2018/92647 Revised Proposals (Mixed Use Development) , Former Kirklees College, New North Road, Huddersfield

05 Accessible Pedestrian Routes into Supermarket

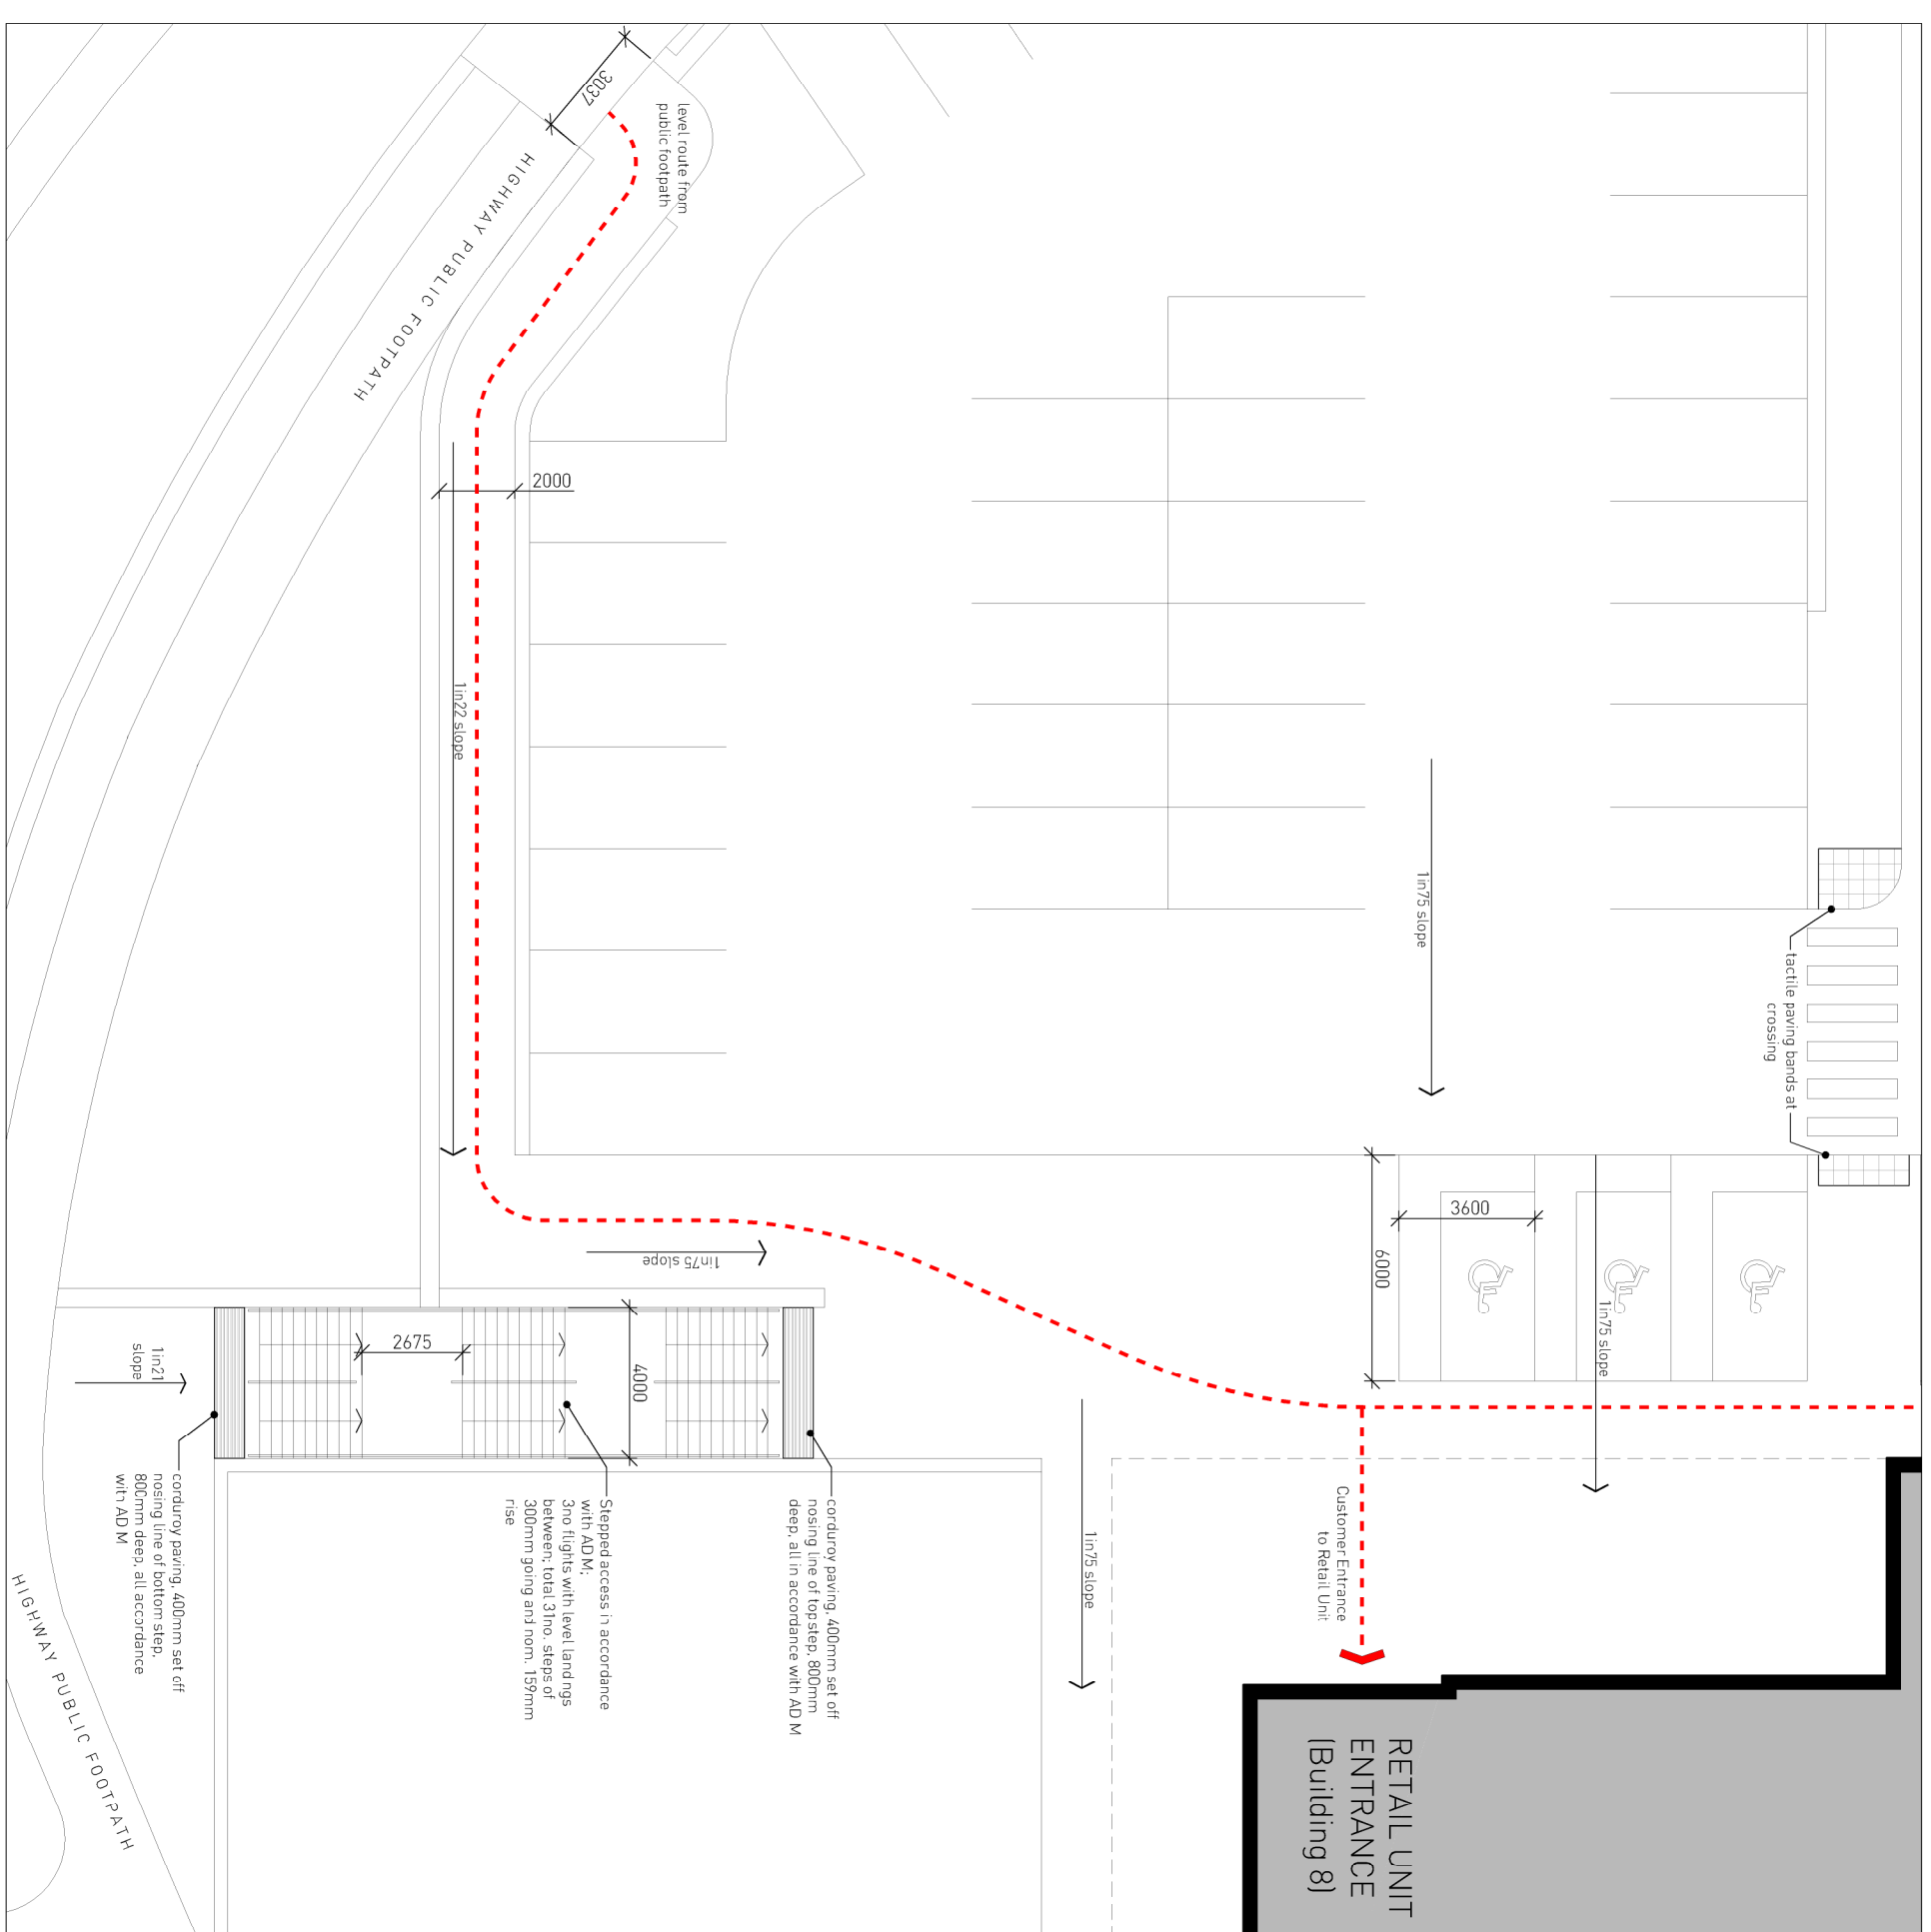
However, the Society wishes to state its strong objection to the elevational details of the proposed supermarket and related car parking. This occupies one of the most prominent sites within Huddersfield, adjacent to Castlegate (ring road) and Trinity Street, the latter providing the main access to and from the M62 motorway. Over the past few years there have been a number of high quality developments fronting the ring road, including those on the university campus and Huddersfield Sports Centre which have complemented buildings of architectural and historic value such as St Paul's Church and Queensgate Market.

The proposed supermarket would appear to achieve even lower standards of design, particularly in relation to these features. It would, therefore, be a retrograde step for approval to be given to this element of the proposal, and contrary to objectives of the Council in promoting good design, on a site which leads to the Station Gateway, where a fundamental ambition within the Council's Blueprint is to enhance the heritage and commercial attractions of the town. Furthermore, this element of the application should, at the very least, undergo some major design revisions coupled with a far greater focus on materials, elevational detail, built form and landscaping, incorporating greenspace with tree planting.
